# Rezoning Transportation Analysis

Petition Number: #2022-109

Date	Description
11-28-22	First Review (IW)
12-21-22	Second Review (IW)
01-25-23	Third Review (TM)

REZONING  
SITE PLAN

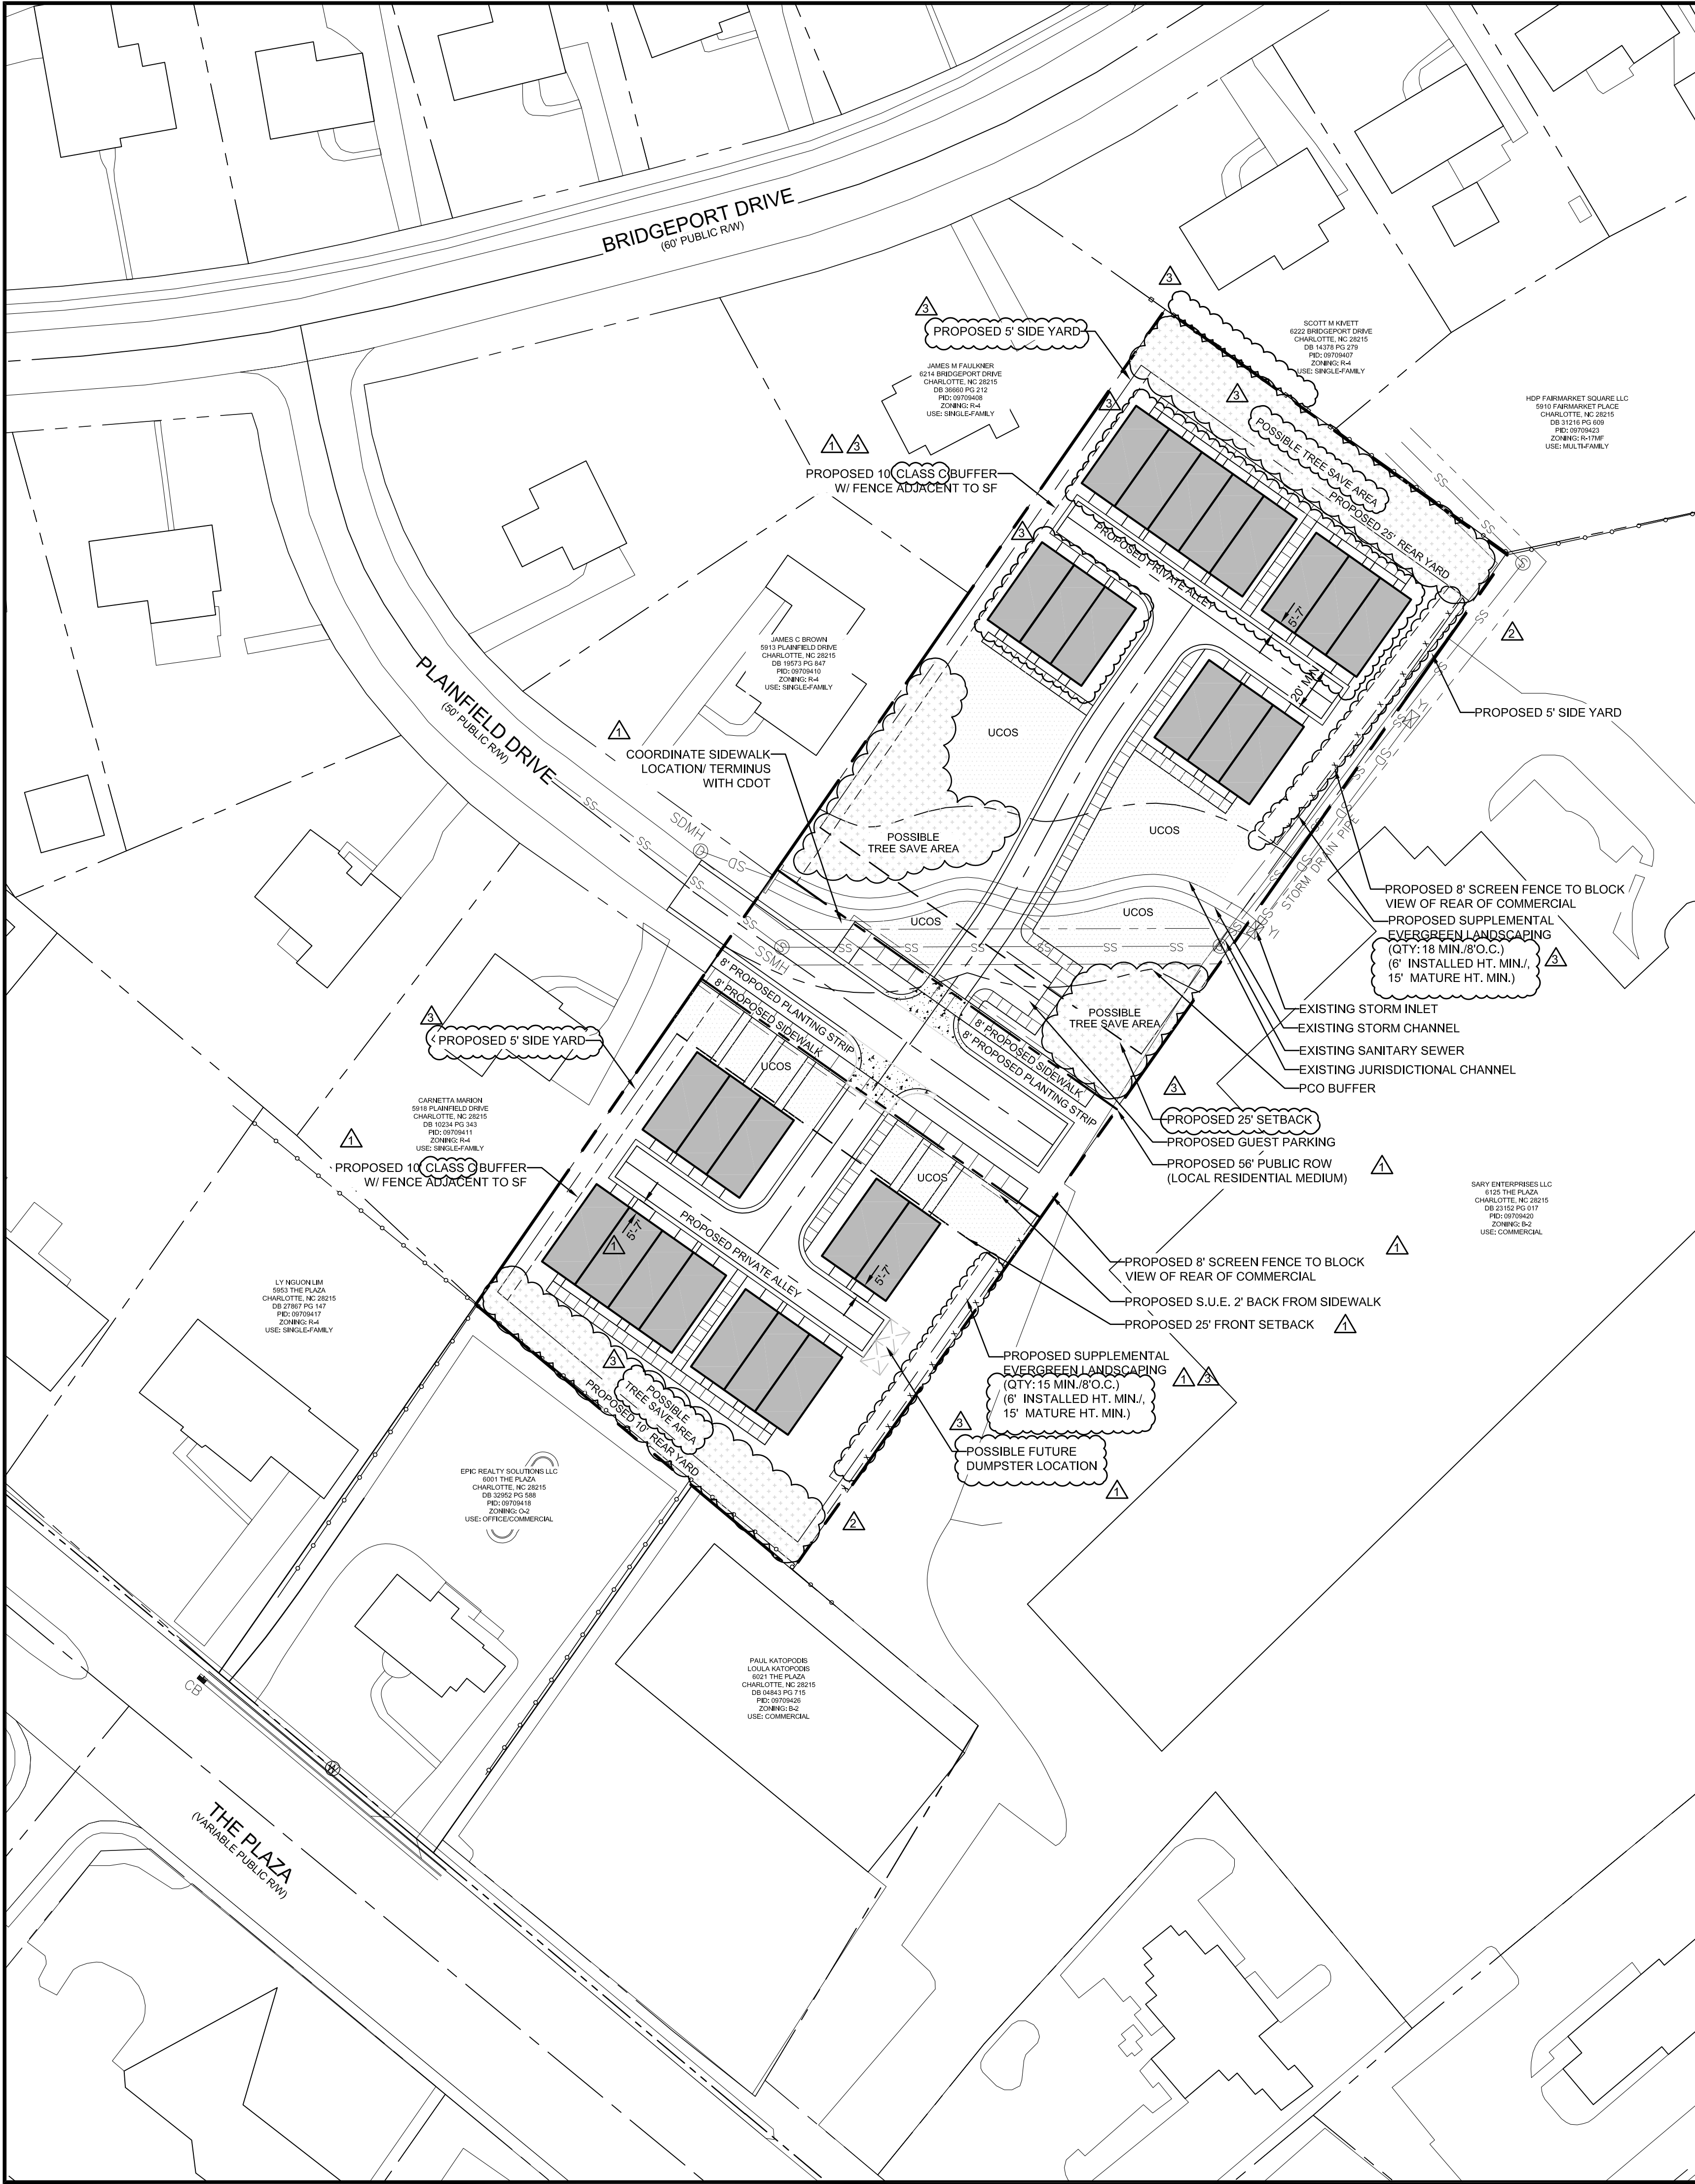
4. The proposed dwelling units exceeds 12 per acre. Per Chapter 20 Subdivision ordinance, site plan and conditional note(s) revisions are needed to commit to construct an 8-foot planting strip, and 8-foot sidewalk along all public roads. The wider sidewalk also meets the Charlotte WALKS Policy.

Reference (CLDSM standard detail U-02) for residential medium street typical.

**Clarifying Comment 12-21-22:** Petitioner should add conditional note stating commitment of 8' planting strip and 8' sidewalk along both sides of all public roads. Reference (CLDSM standard detail U-02) for residential medium street typical section. Potential environmental conflicts to be coordinated during permitting if full section cannot be achieved.
